Bindaree Beef Biodigester and Rendering Plant – SSD 6093

After reviewing the EIS and supporting documentation, I would like make the following comments on the proposal:

Figure 11 Sensitive receivers

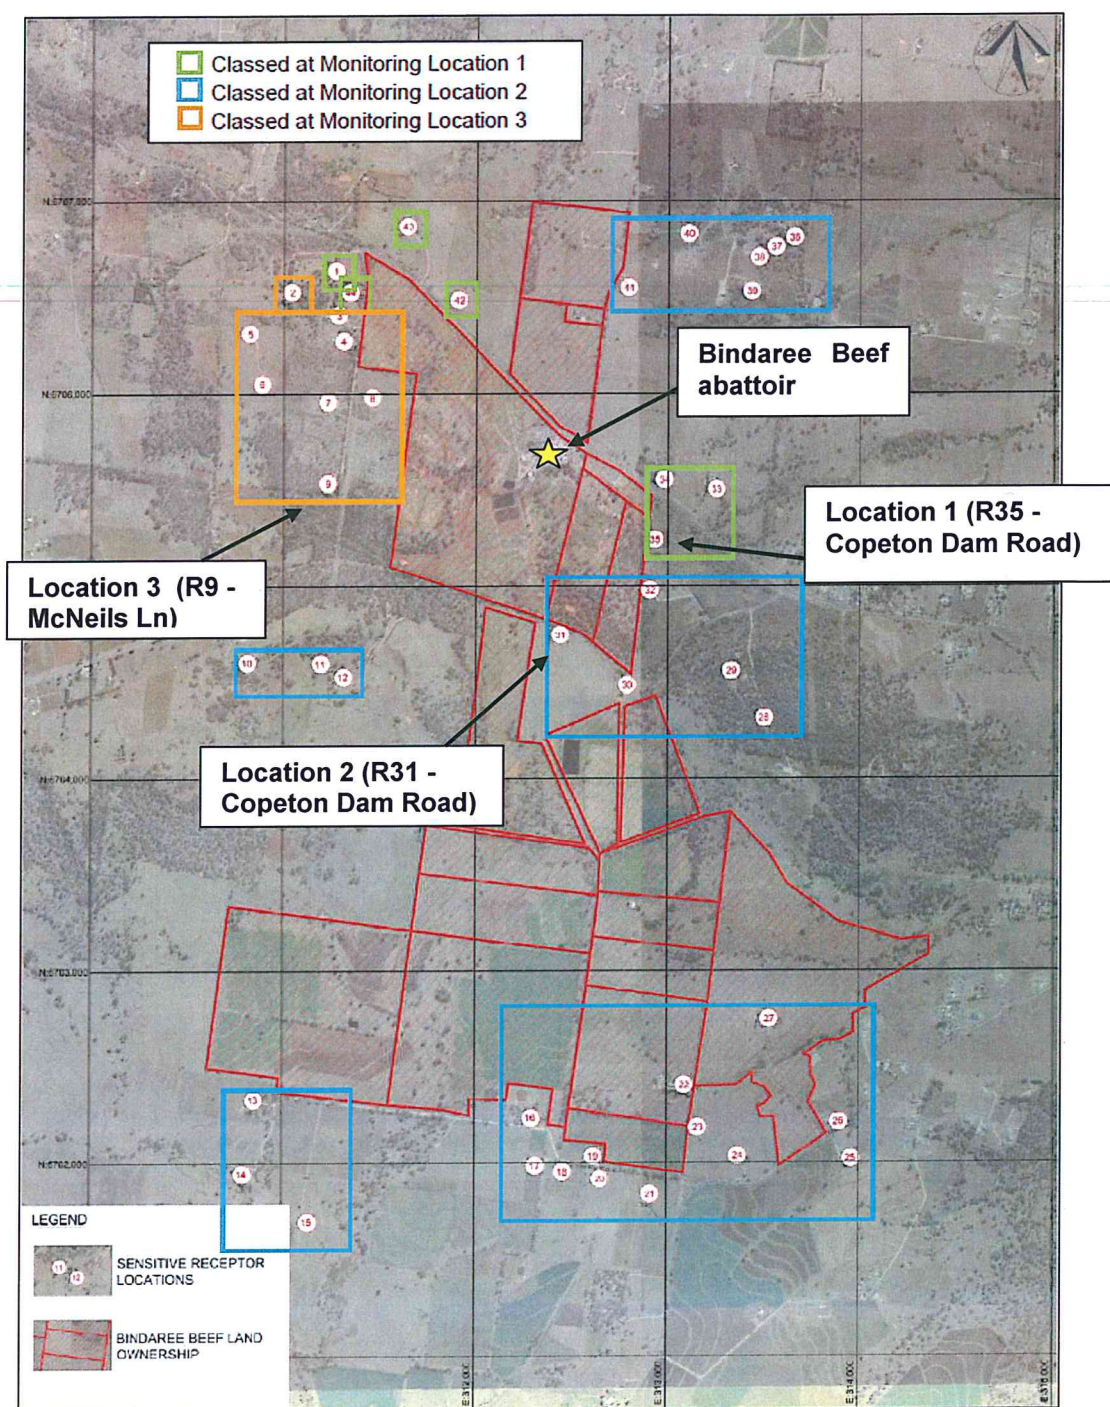
The odour assessment does not include the house at 7218 Gwydir Highway as a sensitive receptor. The house lies approximately 800m from the abattoir and therefore it should be included as a sensitive receptor.

Figure 1. Plot of 100 percentile (maximum) odour predictions

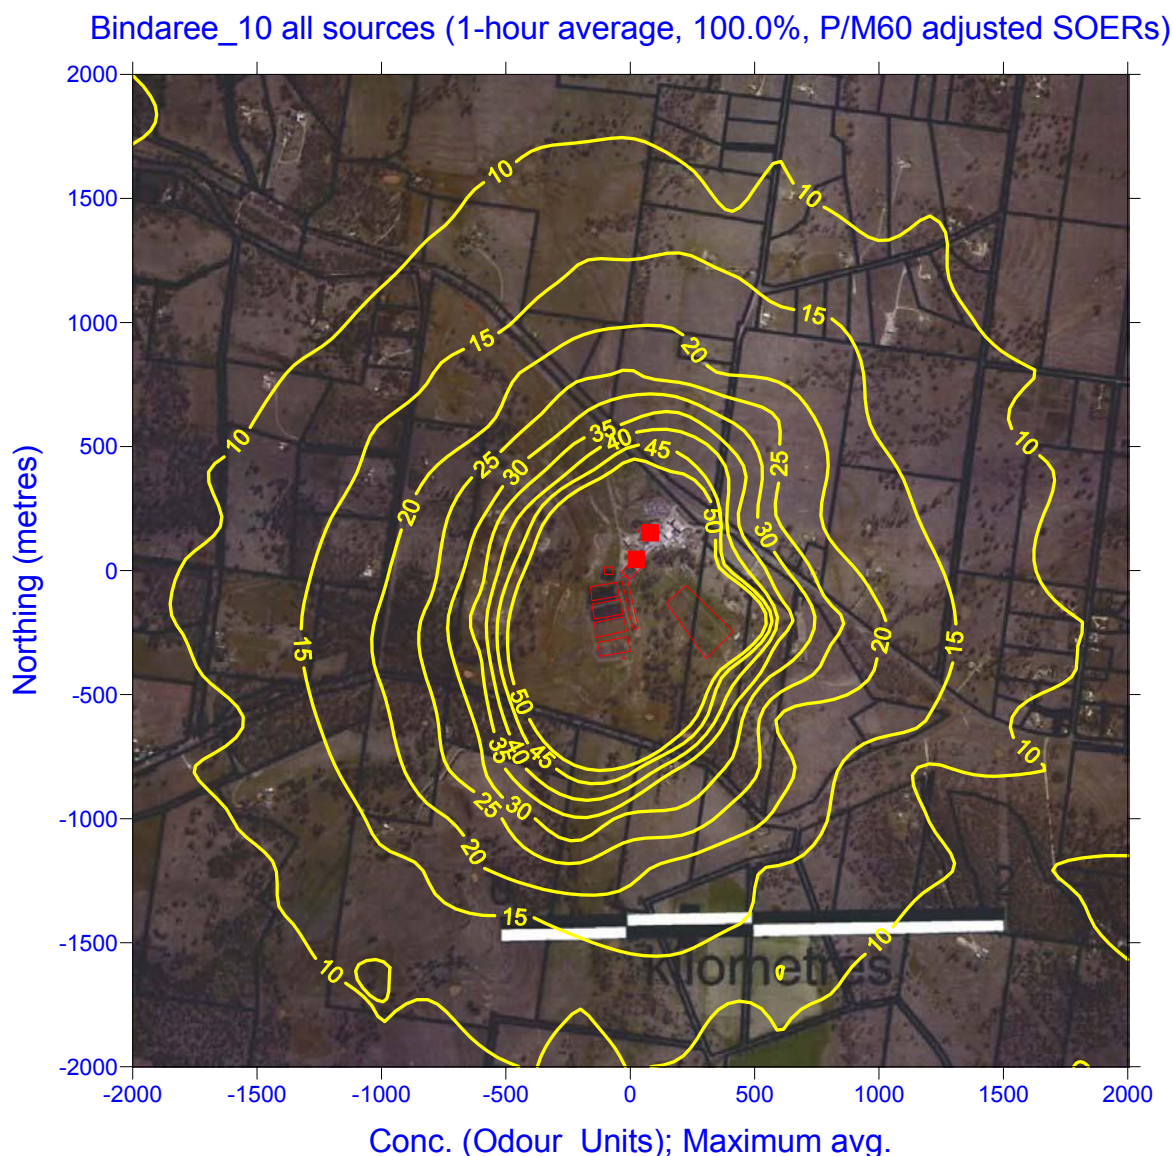
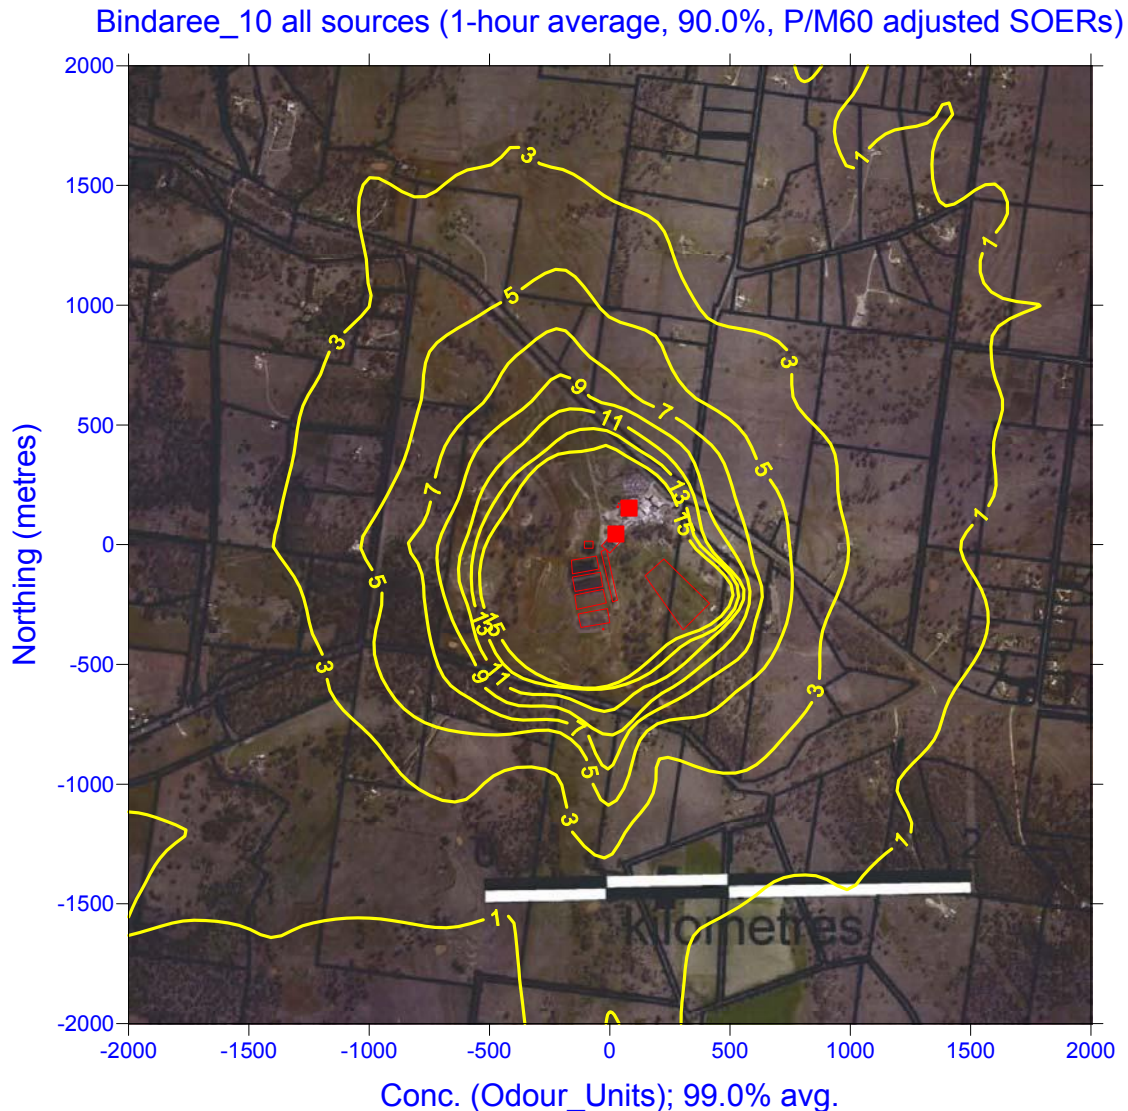
2) Local meteorological data should be used in the dispersion modelling

Historic and current meteorological data exists for the Inverell region at the Inverell Comparison and Inverell Raglan Street meteorological stations. This includes data on wind speed and direction. Local meteorological data should be used in the assessment to ensure it is accurate and site representative.

Further, the dispersion modelling should only use meteorological data during the sensitive day time period. Using data outside the sensitive daytime period distorts the accuracy of the dispersion modelling.
